Conversion of part retail unit & storage area to form 9 No. residential units consisting of
3 No. 1 bed & 6 No. 2 bed dwellings & new access to rear.

107 Felpham Way Felpham

Thank you for your internet representation made on 29th March 2019 which has been recorded as '**an objection**' with the comments as follows:

Drg.No. ADS-002-P. A

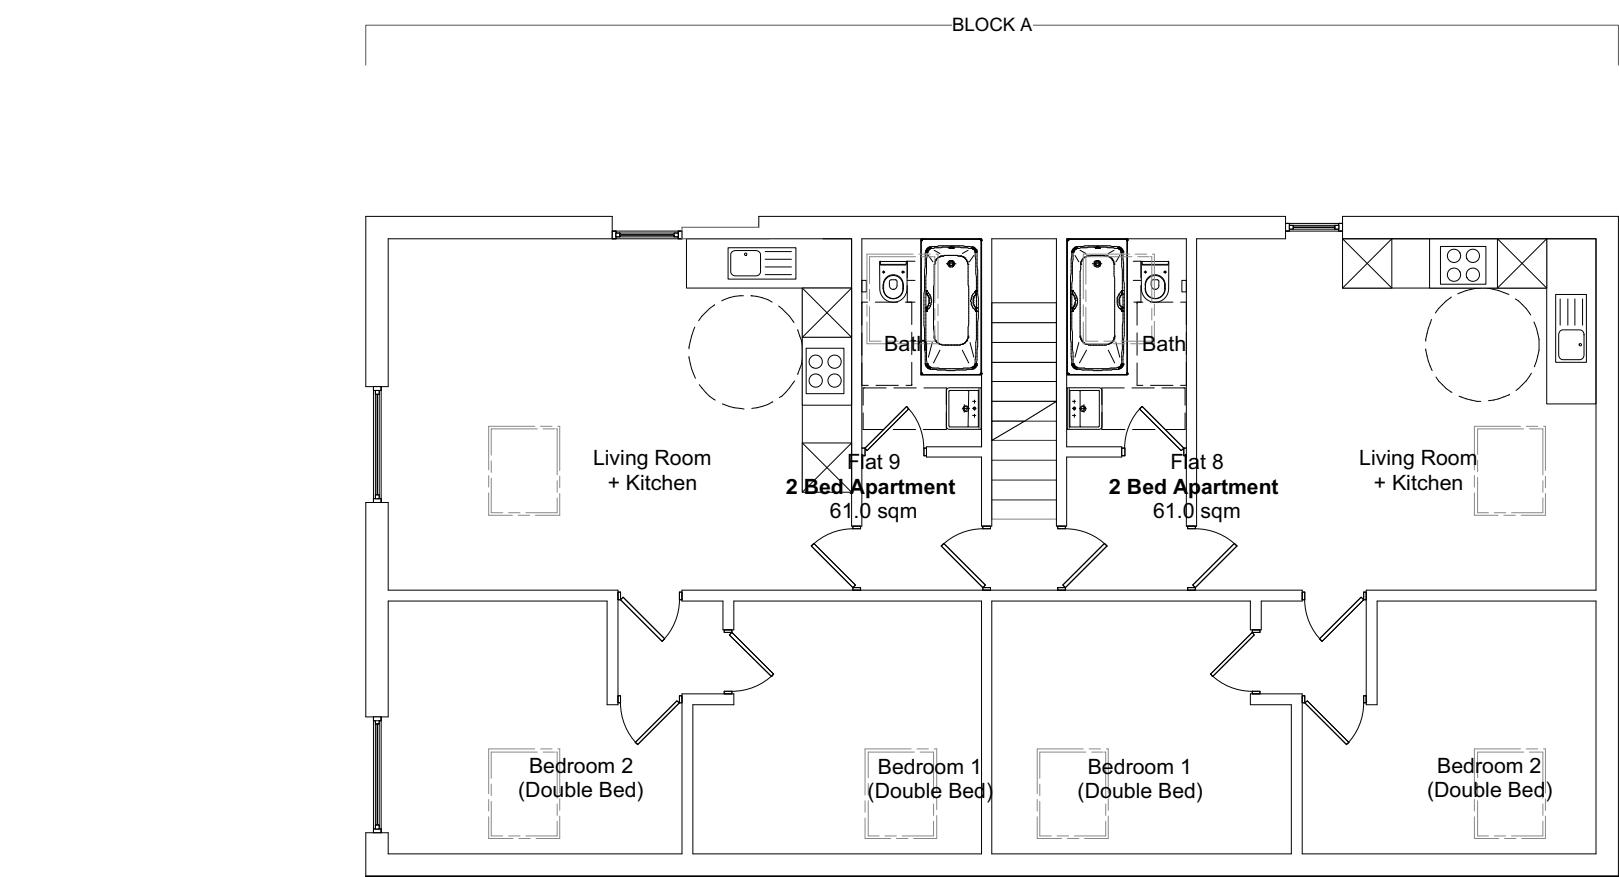
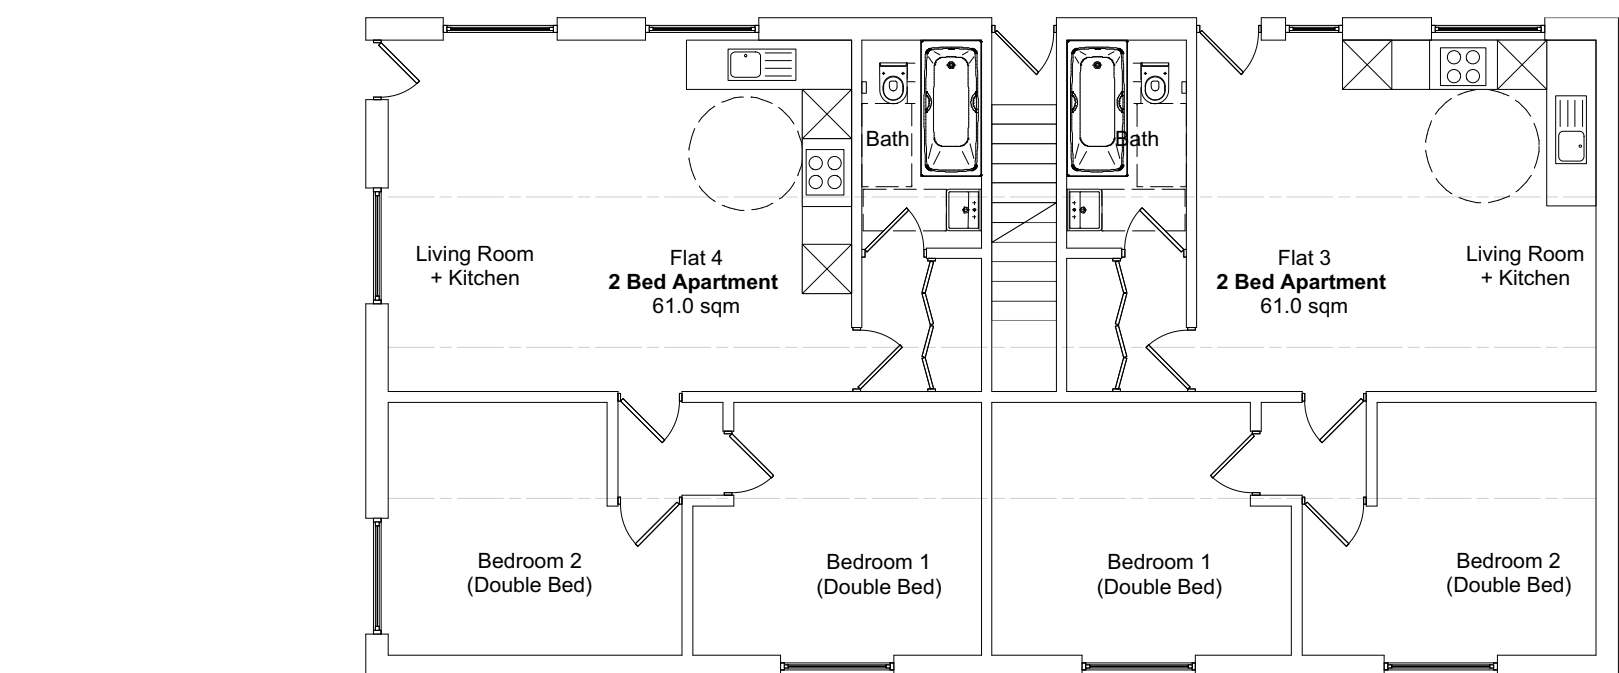
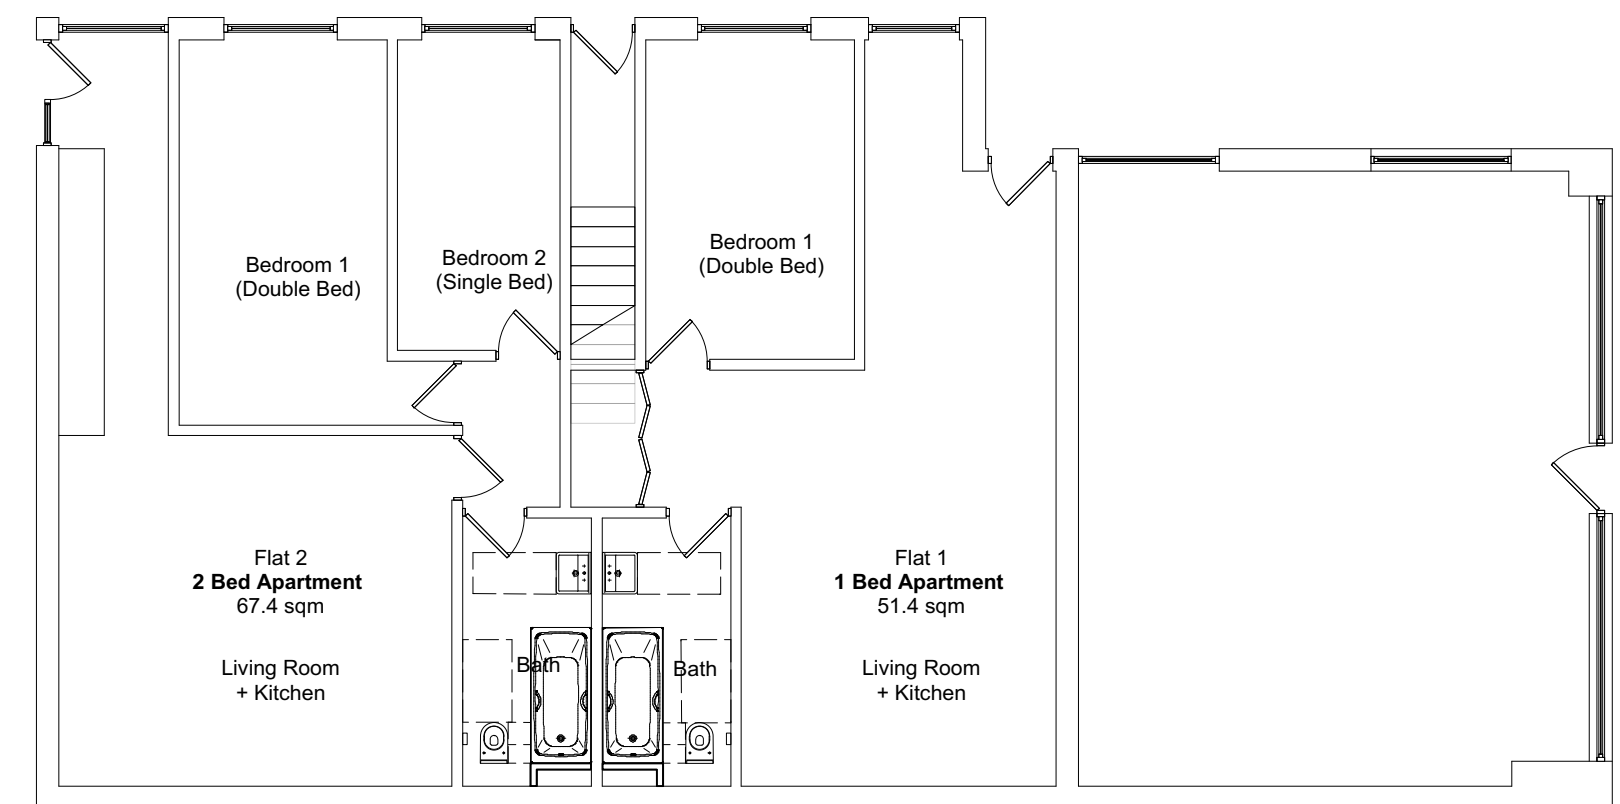
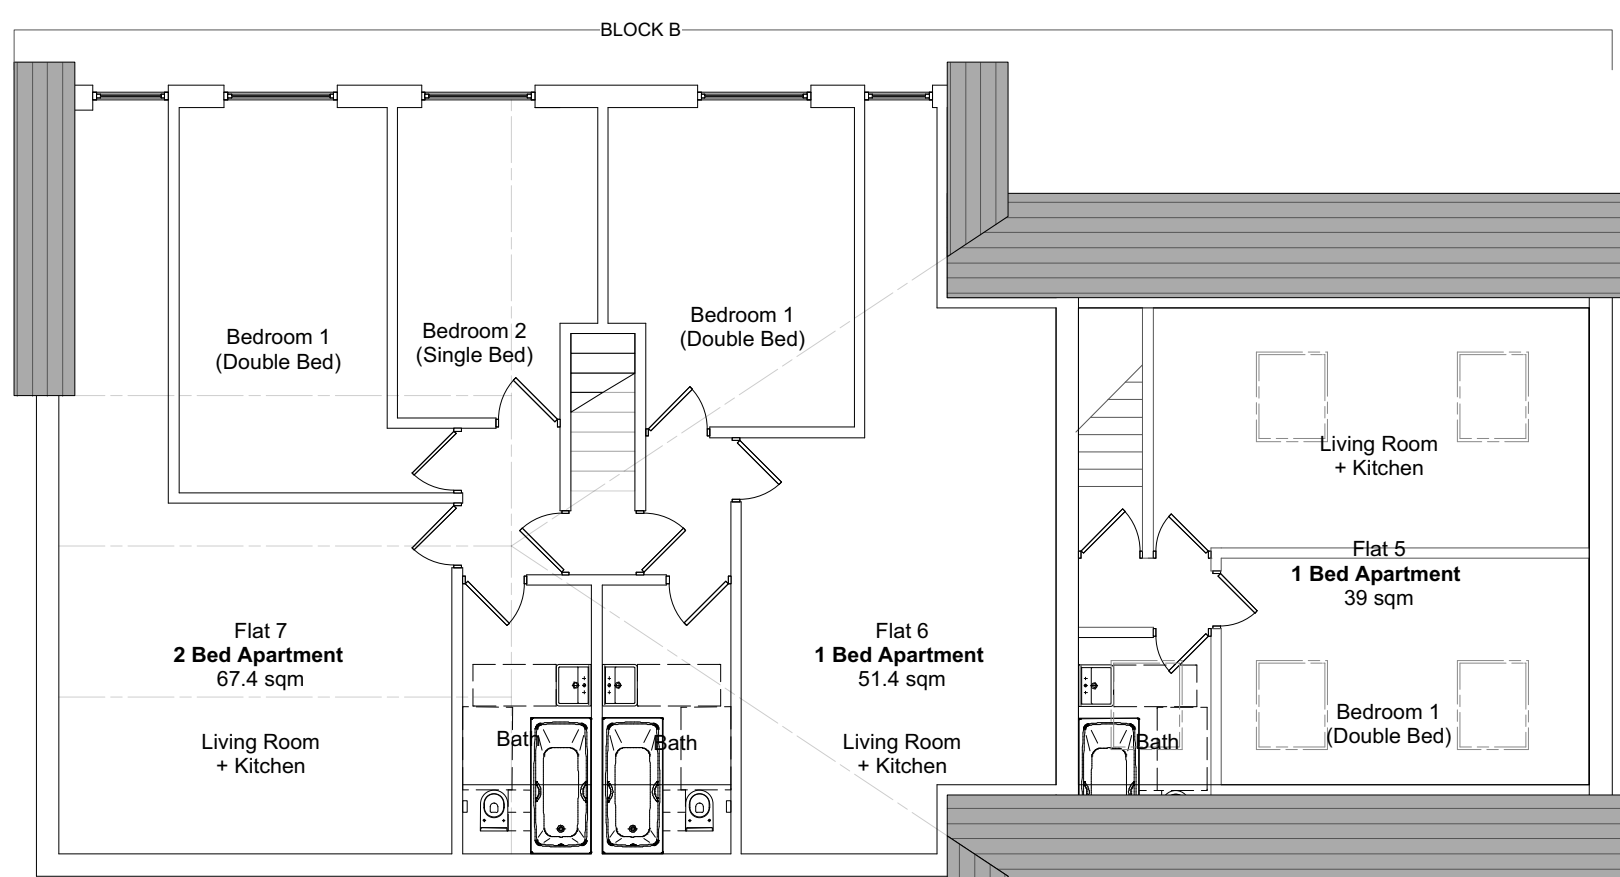
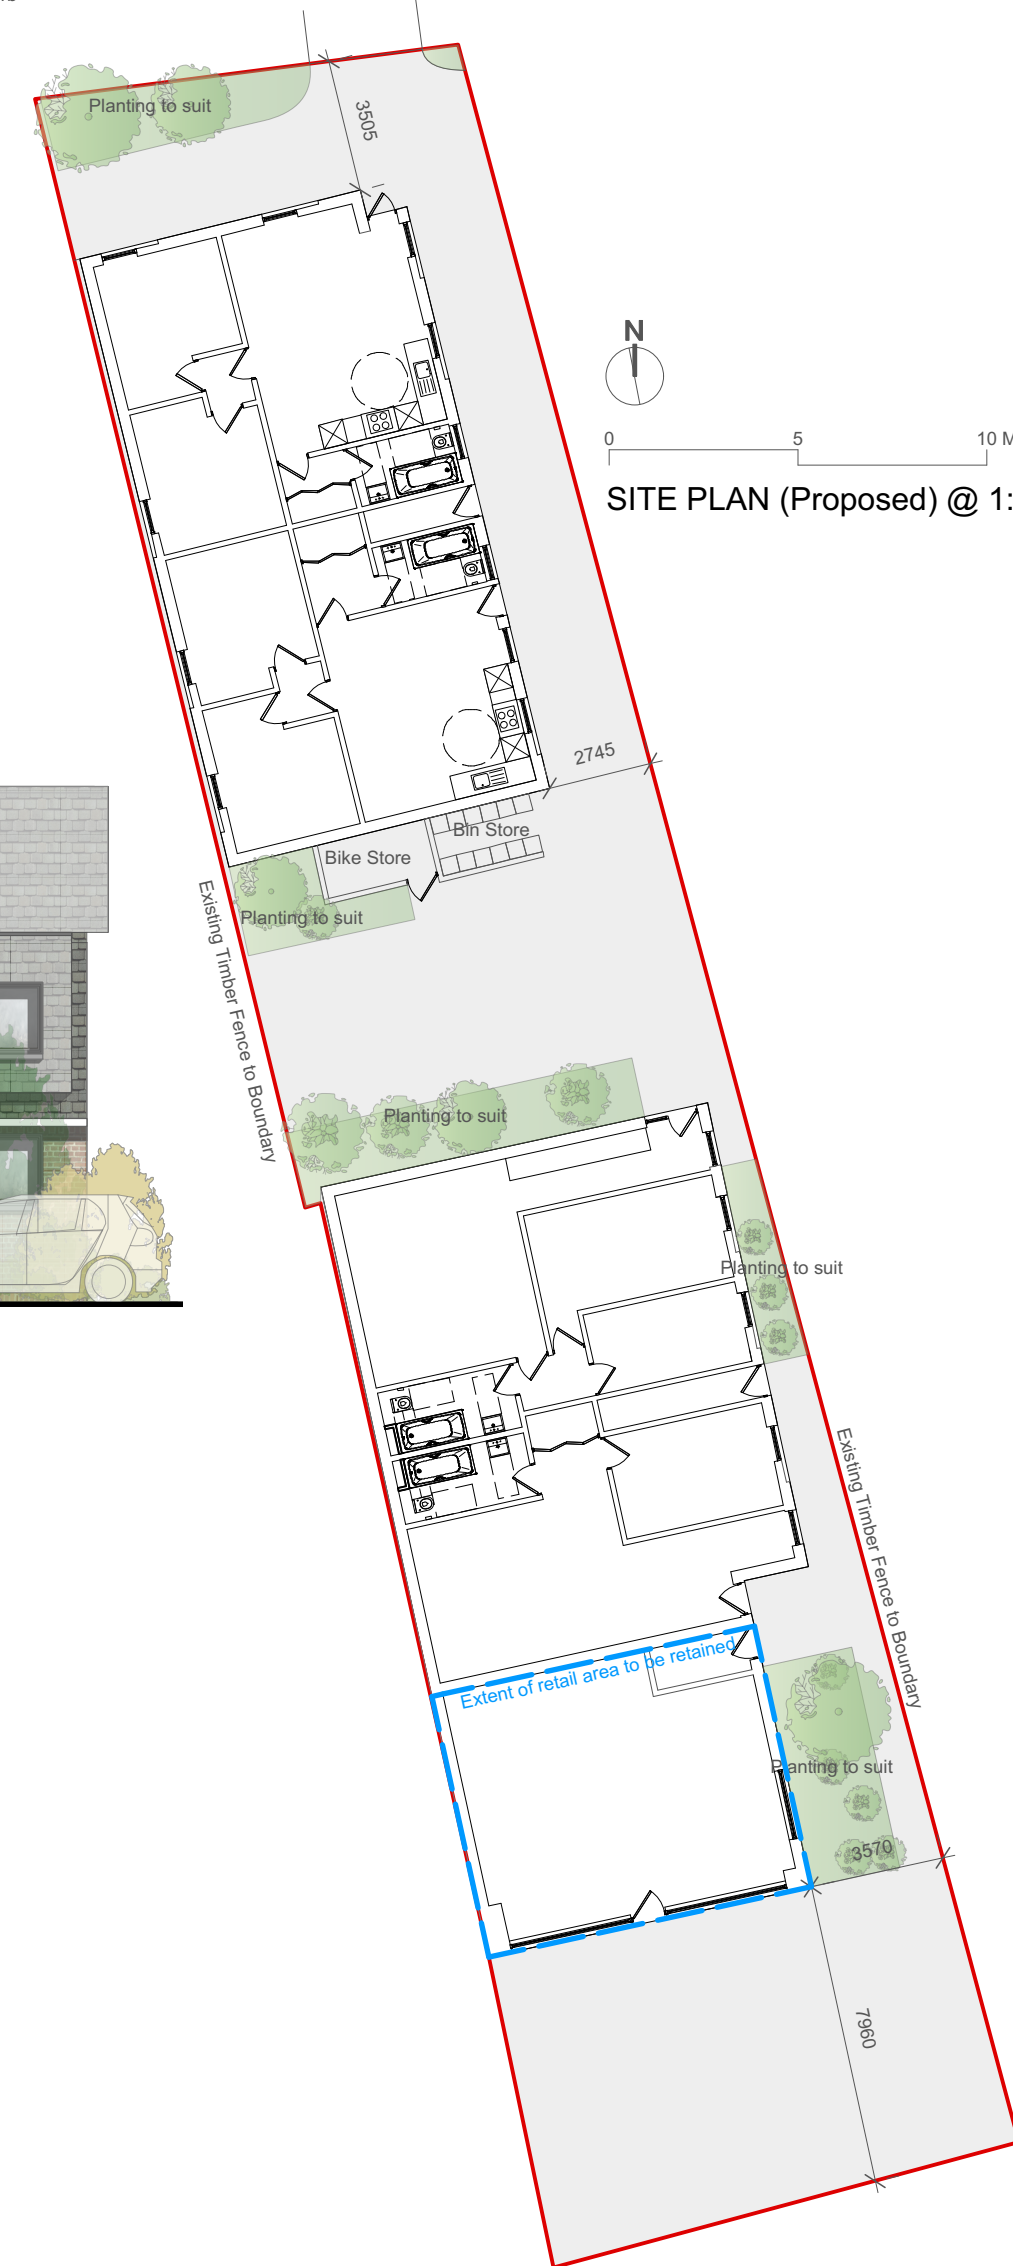
- 1 The northern block touches the boundary of 1 Rainbow Cottages, this would mean all privacy in the garden and rear rooms of 1 Rainbow Cottages would be lost; unless all overlooking windows were of obscured glass. Alternatively the block should be move further east, unfortunately this would then cause similar problems to 2 Sunnyside Cottages.*

- 2 Parking spaces for 9 flats. We would anticipate approximately nine vehicles have not been provided for within the boundaries of the development. Given 6 of the proposed flats are for 2 bedroom flats one should work on the principle that a possible 15 cars could need to be regular accomodated, without the need for visitor parking.*

- 3 Access to the blocks is via Flax Mean. This is a cul-de-sac with very limited parking space for the private properties and council bungalows accessed at present. Access is also required for emergency vehicles given that all of the Flax Mean properties are for those over state pension age.*
